Application number: 2026/91124	
What is the application for?:	Variation of condition 2 (plans) on previous permission 2025/90493 for demolitio
Address of the site or building:	11, Town End Avenue, Wooldale, Holmfirth, HD9 1QW
Postcode:	HD9 1QW

DRAWING TITLE:
Elevations, Sheet 2 of 2

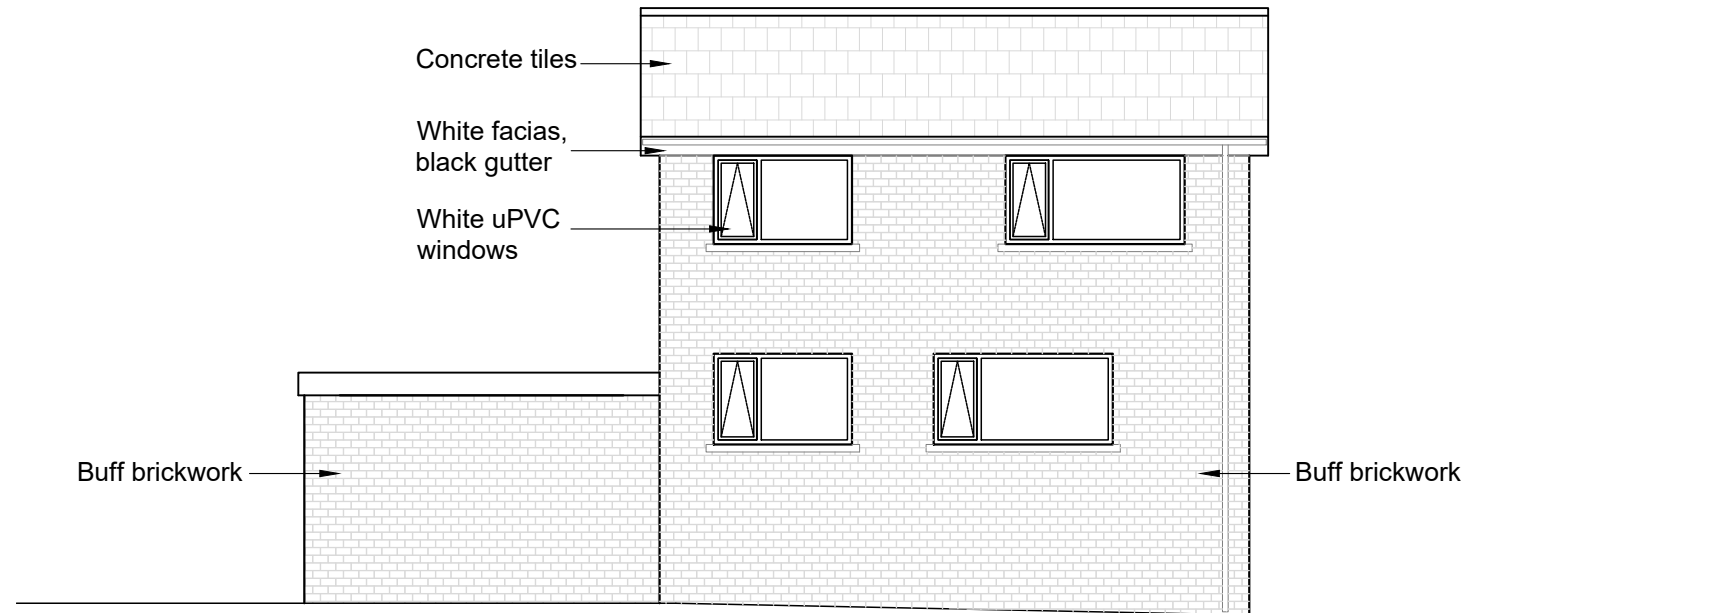
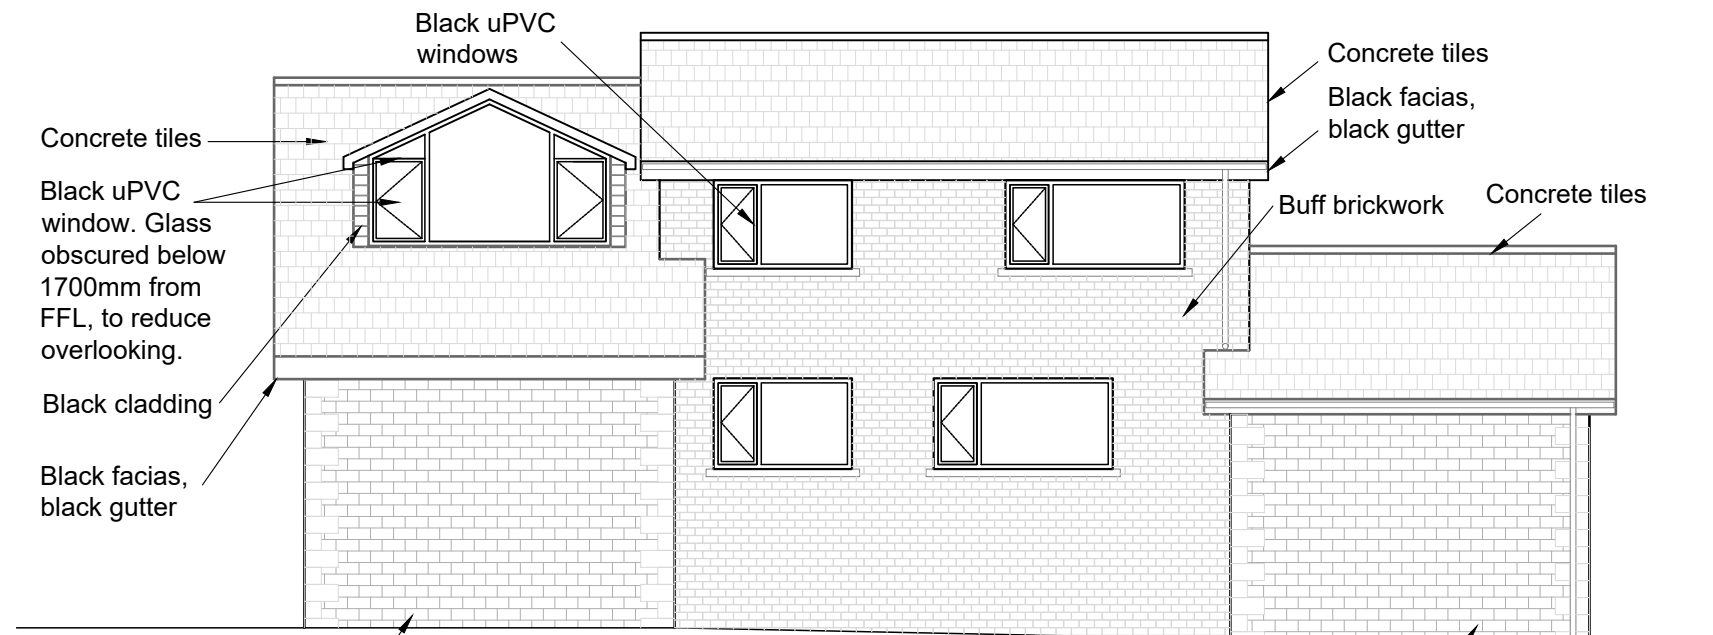
Type of comment: An objection	
Do you wish your comments to be published on the website anonymously?	Yes
"Very minor changes to window levels to suit coursing". Which windows? What are the proposed minor changes? This needs to be specified as inadequate information. This issue effects neighbouring properties to rear, side and front of No 11 on both Town End Avenue and Town End Crescent.
